PLANNING CONSULTATION RESPONSE

Application No	2025/1095
Proposal	Replacement of existing windows and widening of existing doorway and the installation of new rooftop plant.
Address	Barnsley District General Hospital, Gawber Road, Old Town, Barnsley, S75 2EP
Date of Consultation Reply	25/02/2026
Consultee	Pollution Control

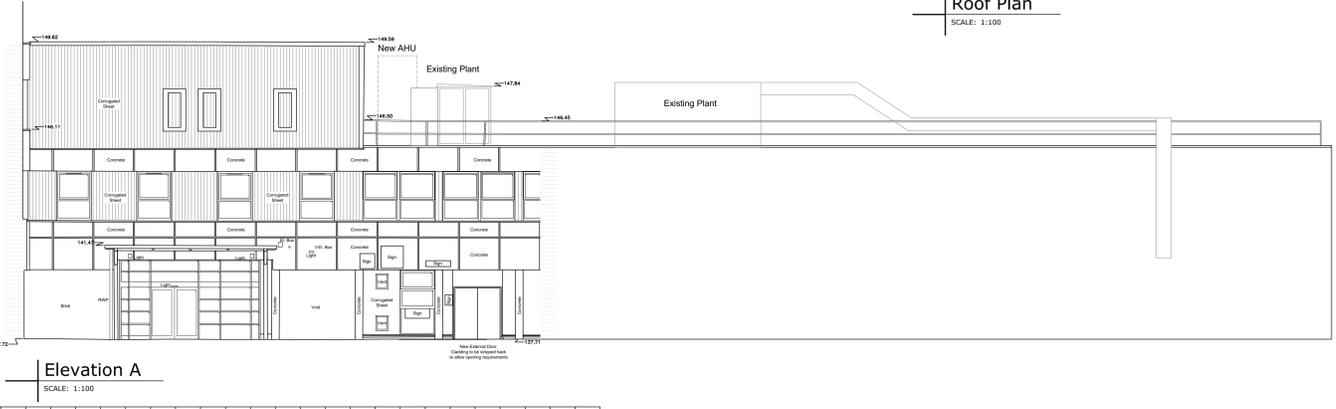
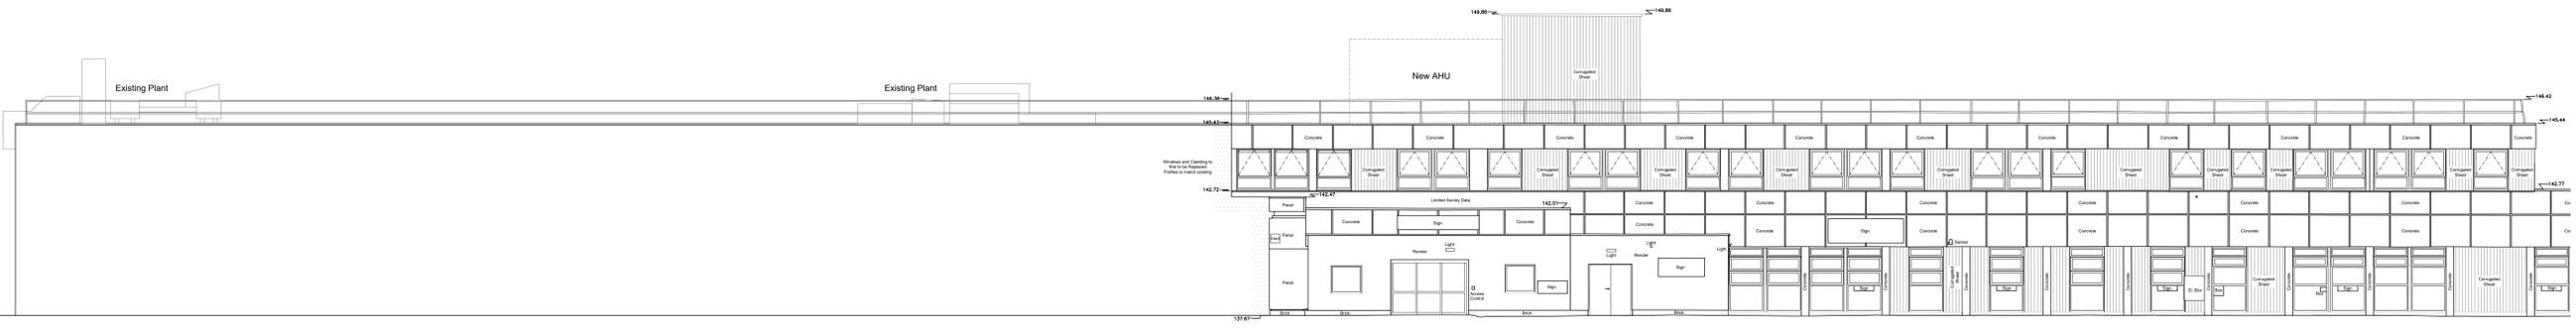
There is insufficient information provided regarding the noise outputs from the plant and the proposed attenuation, to be able to determine whether there is likely to be an adverse impact for residents living nearby. Additional information is required in the form of a Noise Impact Assessment carried out by a suitably qualified acoustic consultant/engineer which follows the principles contained in BS 4142:2014 Methods for rating and assessing industrial and commercial sound.
